RE: SEPA comments on the Determination of Nonsignificance issued by the County regarding SEPA Checklist (SE-22-00002).

1) We are submitting SEPA comments on the Determination of Non Significance issued by the County regarding SEPA Checklist (SE-22-00002).

Parcel #19162 Driveway Improvement Extents

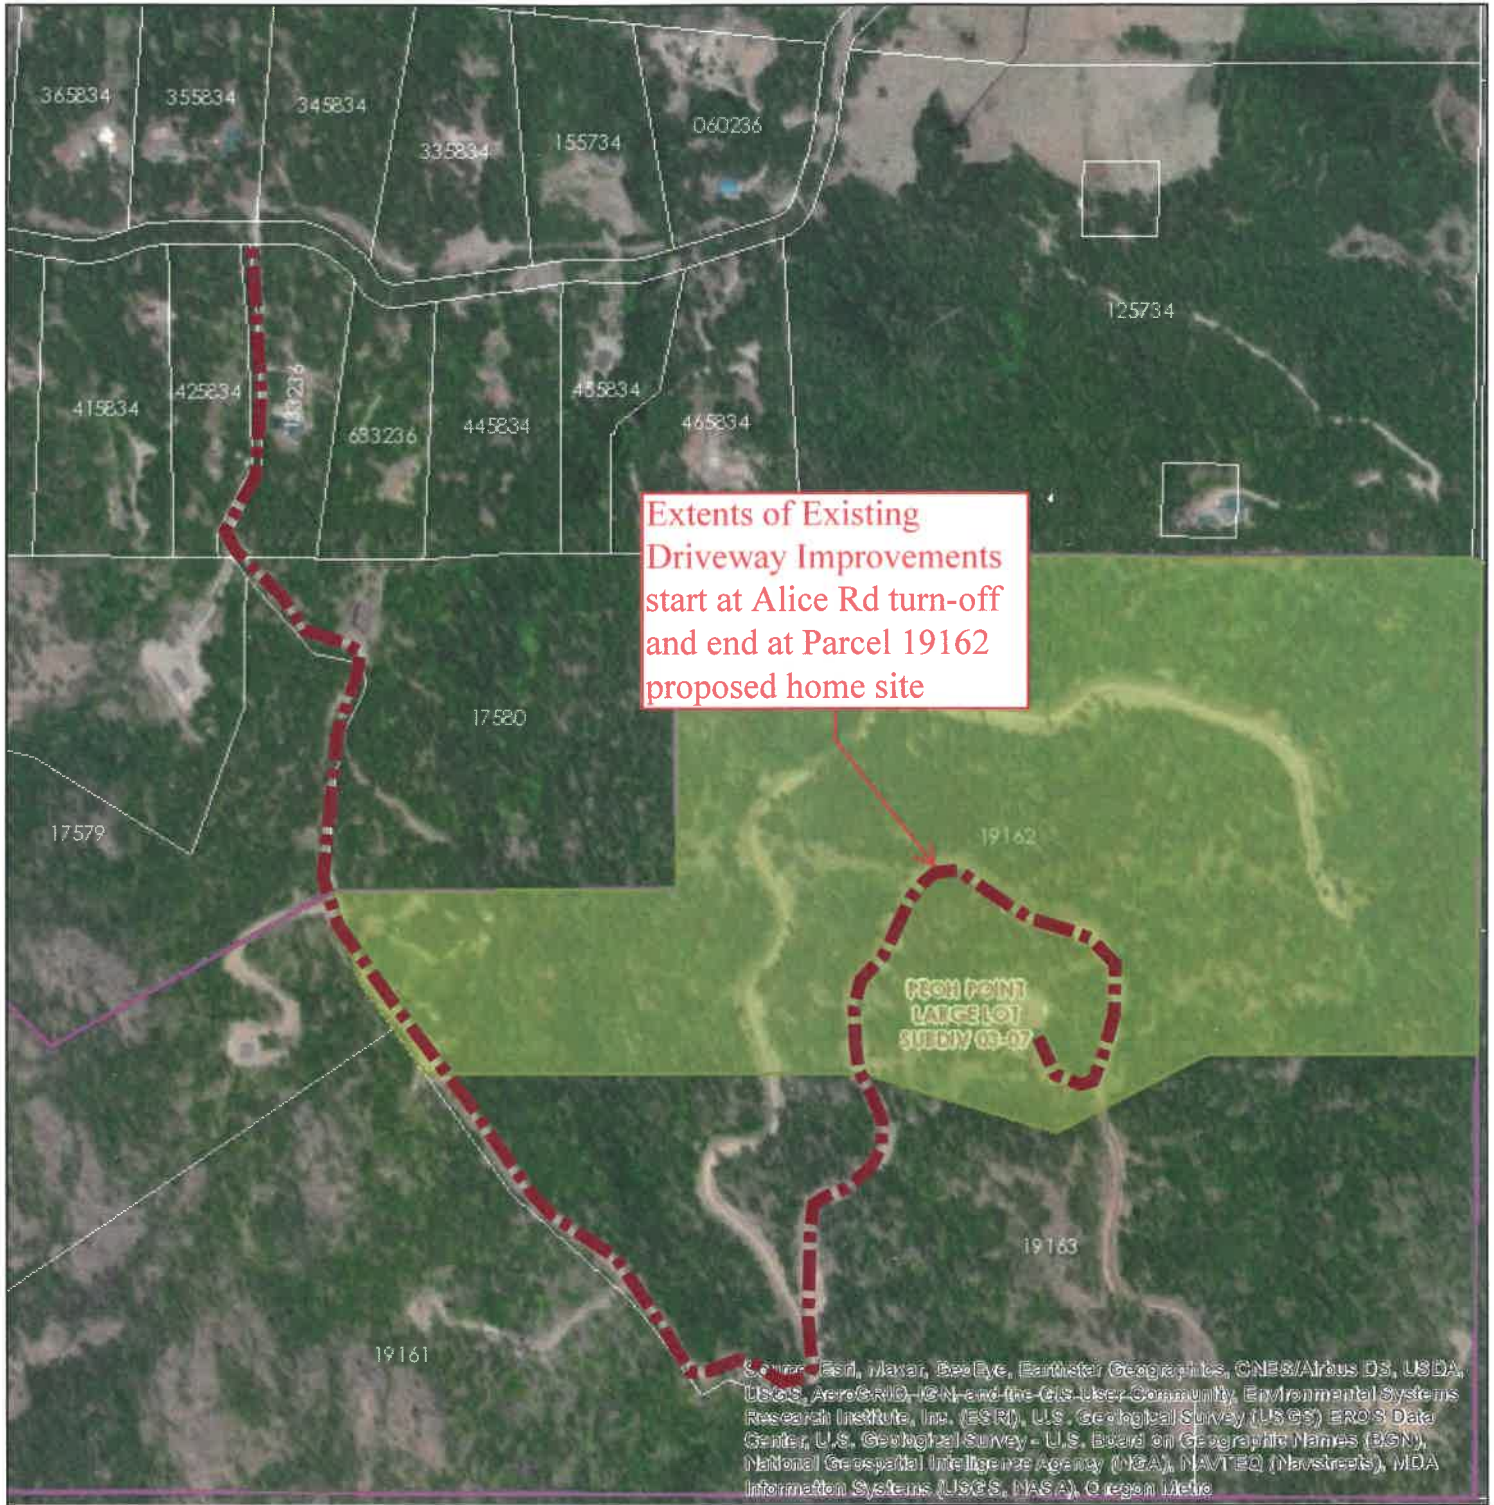
The SEPA checklist and project proposal did not properly identify or account for all of the parcels and users that are served by the access road. The access road serves 9 parcels, five of which already have addressed residences in place, and so is not a "driveway" as defined by the County codes.

The proposed project involves road grades that are too steep to comply with the County's minimum design requirements for a private road. This point alone should prevent approval.

The easement from Alice Road through the Little Peoh Point Tracts (LPPT) is too narrow to meet the County's minimum design requirements for a private road.

- SEPA comments from the Public Works department indicated that the developer would be required to bring Alice Road up to private road standards. However, that full project scope was not identified in the SEPA checklist or evaluated by the County in making its SEPA determination.

4) We hereby request that the County withdraw the DNS based on insufficient information from the applicant regarding an accurate accounting of the parcels being served by the access road, and the full project scope as it impacts Alice Road. Also request that any determination should include mitigating conditions that will ensure that Alice Road is not damaged and that the applicant would be solely responsible for any improvements or conditions that the County may require.
